REF: WTJ21-087

PROPERTY AT 20 AVON ROAD, PYMBLE GREY HOUSE PRECINCT SSD-17424905

We write in response to the **SSD-17424905**, submitted on behalf of Pymble Ladies College (PLC) for the Grey House Precinct (GHP). Specifically, this letter and attachments responds to the conflict between the proposed GHP development, and the existing Concept Approval consented under **SSD-5314**.

PROJECT PLC Masterplan Phase 2					
CLIENT Pymble Ladies' College					
DRAWINGS Overall Staging Plans					
CLIENT REF & CONTACT Avon Road, Pymble					
DATE Aug 2022	DRAWN SC	PROJECT# 2126	DWG# DA009	REVISION C	
SCALE 1:1000	CHKD

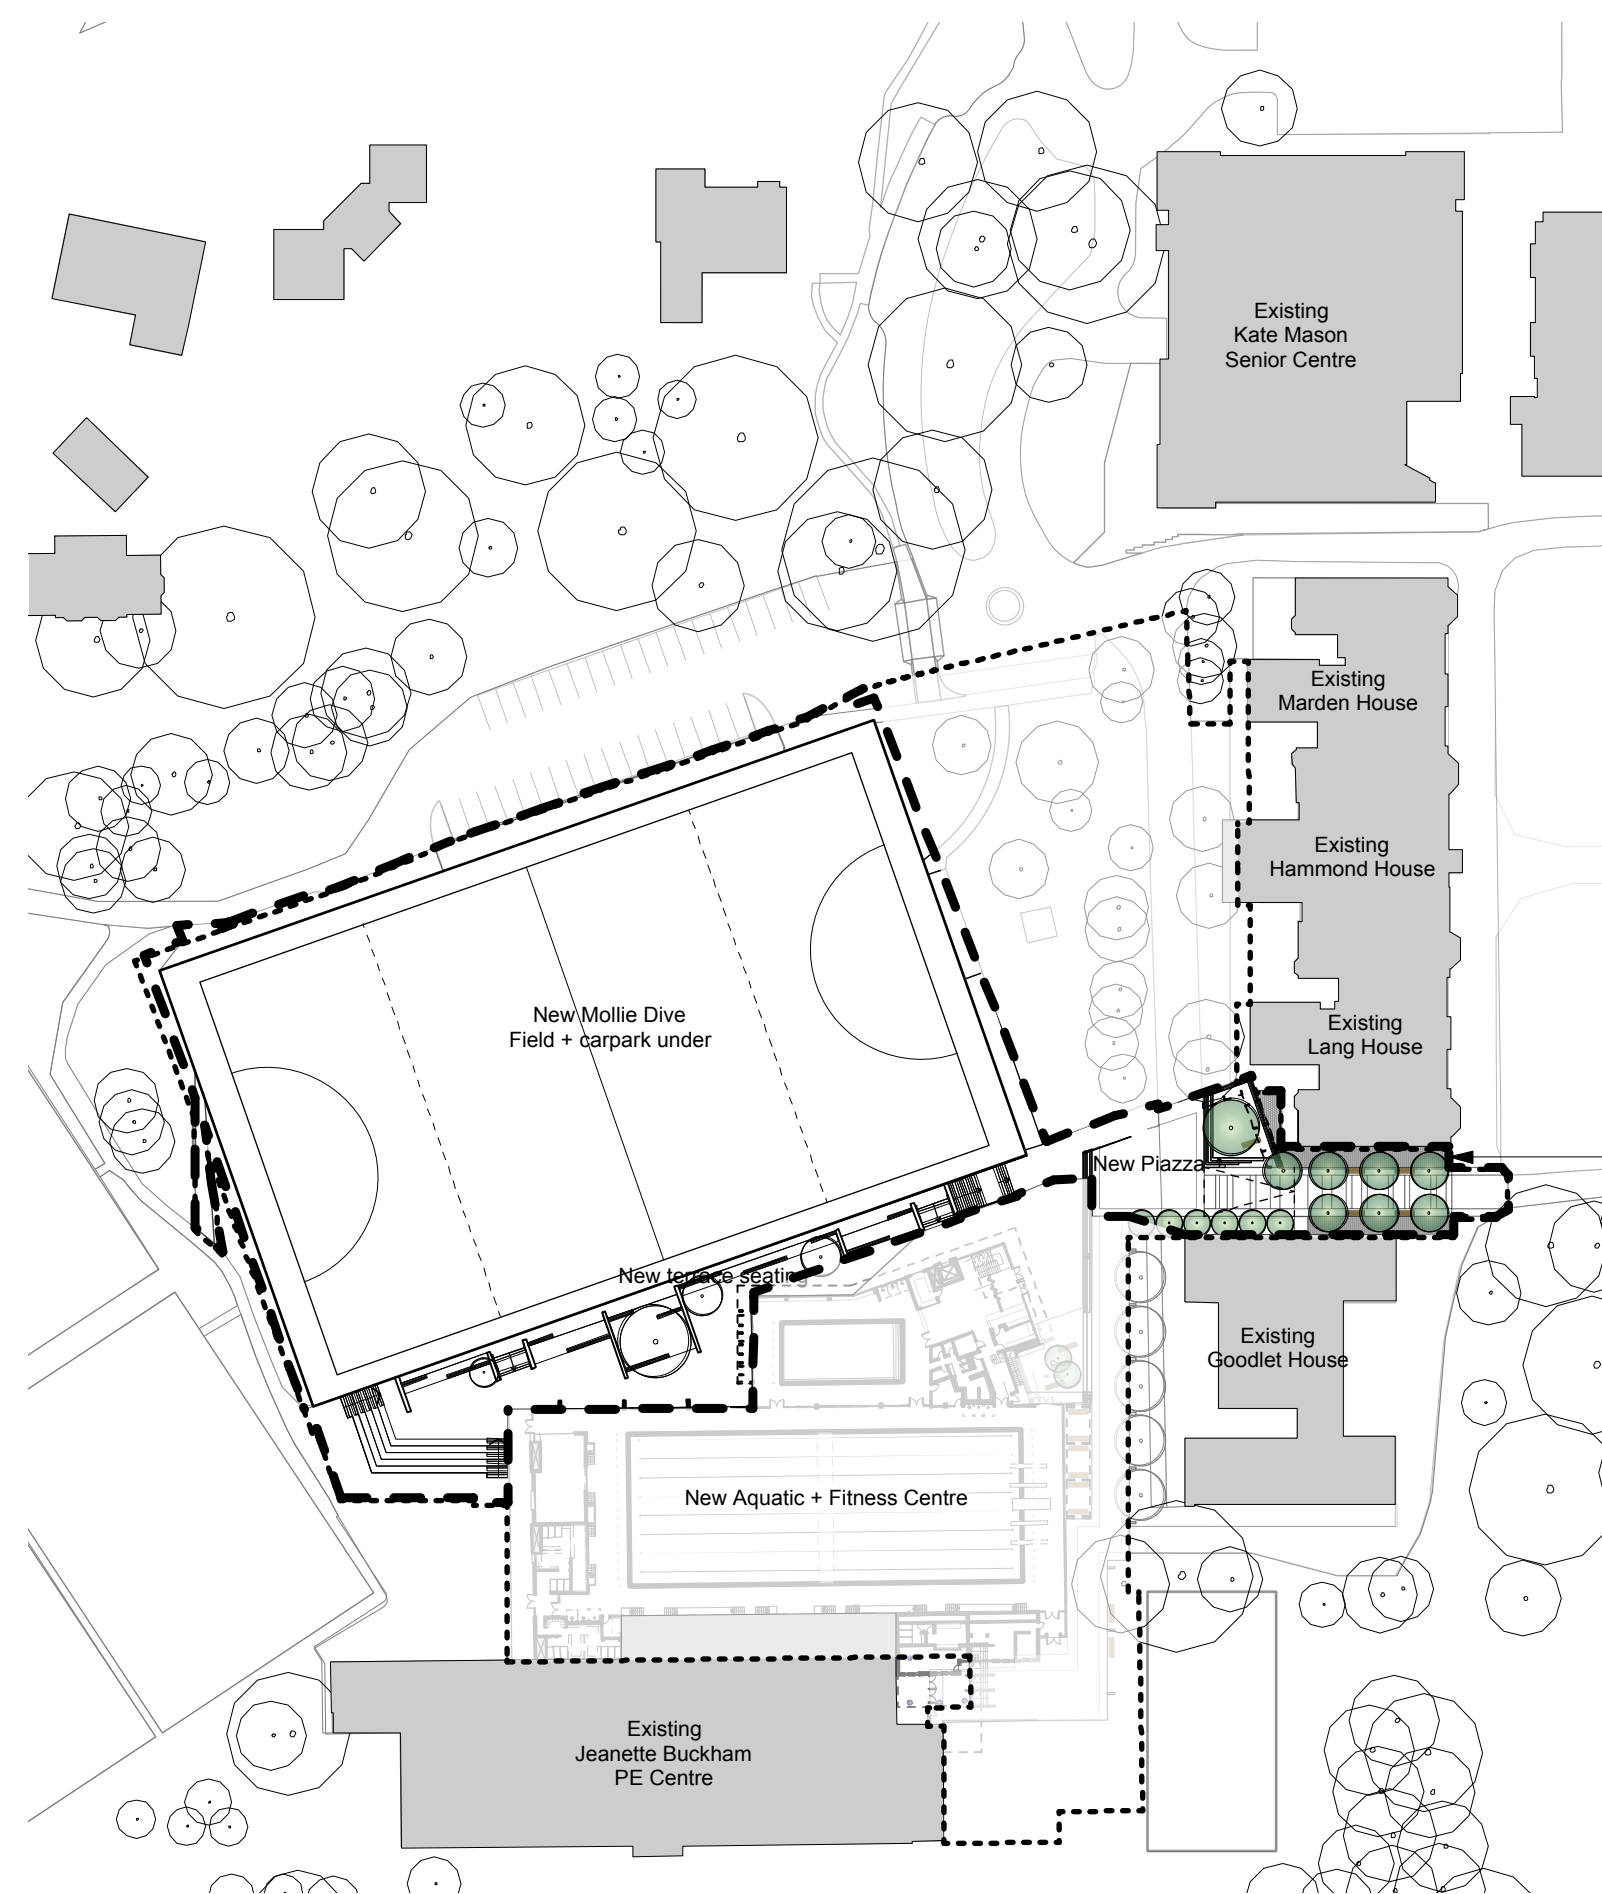
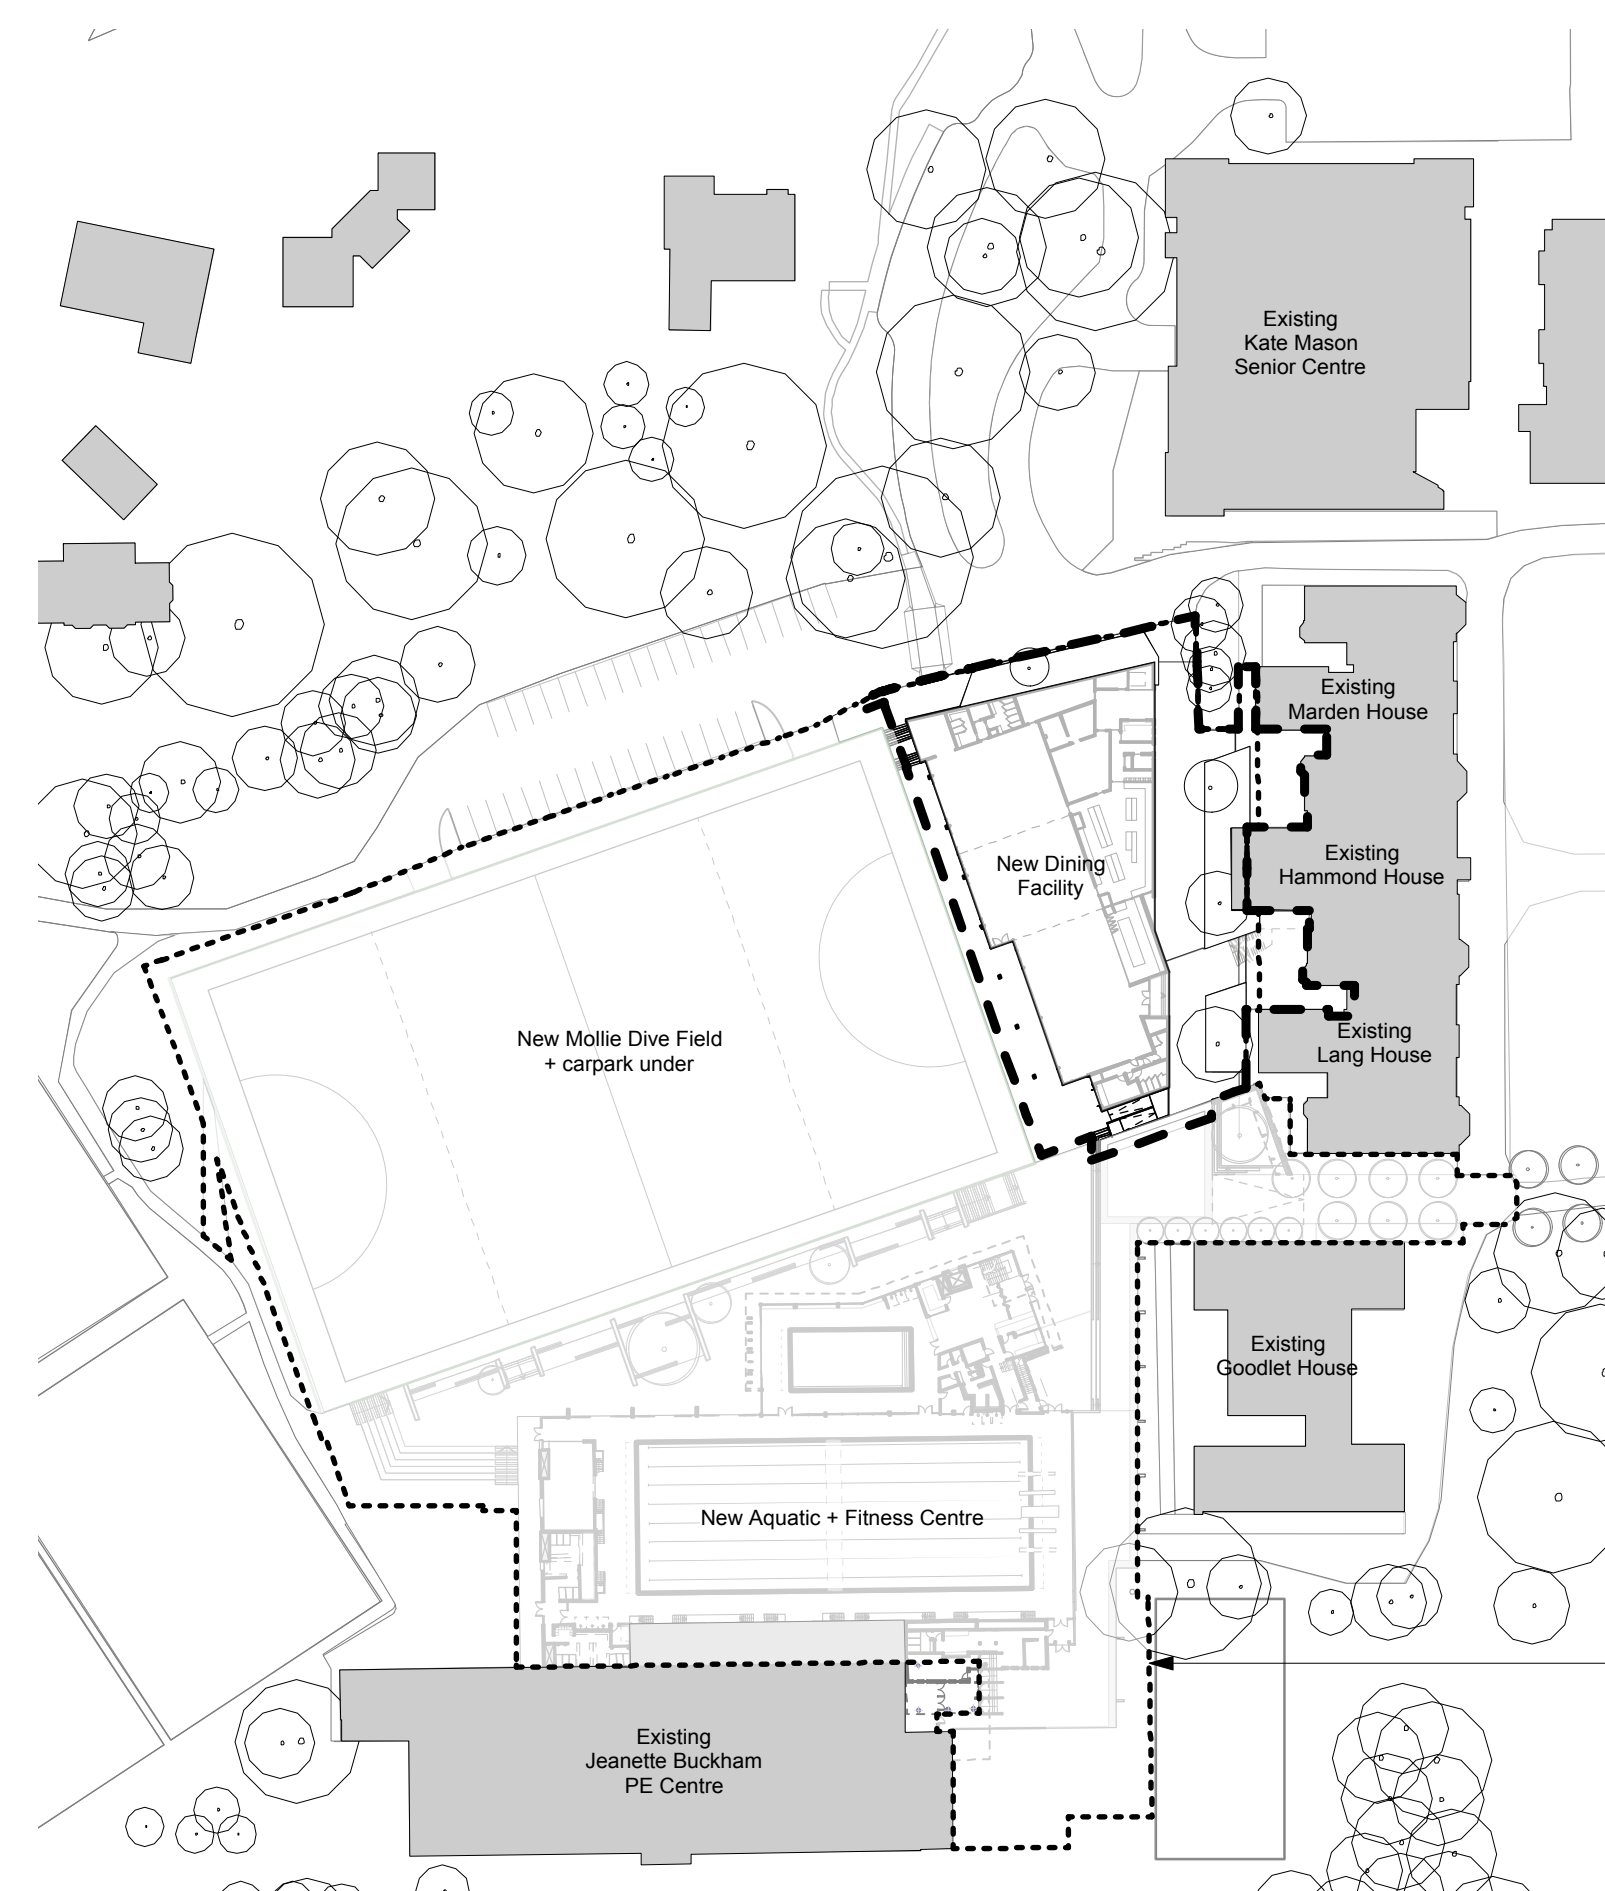
Concept Proposal			
Architectural (or Design) Drawings prepared by <i>PMDL Architecture & Design Pty Ltd</i>			
Drawing No.	Revision	Name of Plan	Date
DA009	B C	Overall Staging Plans	August 2012 2022
DA010	B	Overall Ground Level Site Plan	August 2012
DA011	B	Overall Upper Level Site Plan	August 2012
DA012	B	Overall Lower Level Site Plan	August 2012
DA020	B	Overall Site Elevations	August 2012
DA030	B	Overall Site Section	August 2012
Landscape Drawings prepared by <i>Taylor Brammer Landscape Architects Pty Ltd</i>			
Name of Plan			Date
PLC Aquatic Centre, Mollie Dive Field and Dining – Landscape Concept			11 October 2011

~~B2. The Healthcare Centre is restricted to a maximum height of RL 126.82 metres AHD and is to be contained within the building envelopment illustrated on the approved plans referenced in Condition A5 of Part A of Schedule 2.~~

This modification is required, as the healthcare centre building envelope conflicts with the proposed GHP building, and as such both consents could not be enacted at the same time. Furthermore, the proposed GHP includes the relevant facilities that were envisioned for the healthcare centre as part of Stage 4 of the original concept proposal under **SSD-5314** and as such it is considered that the proposed modification of this consent would not impact on the delivery of the overall intention of the masterplan for the School.
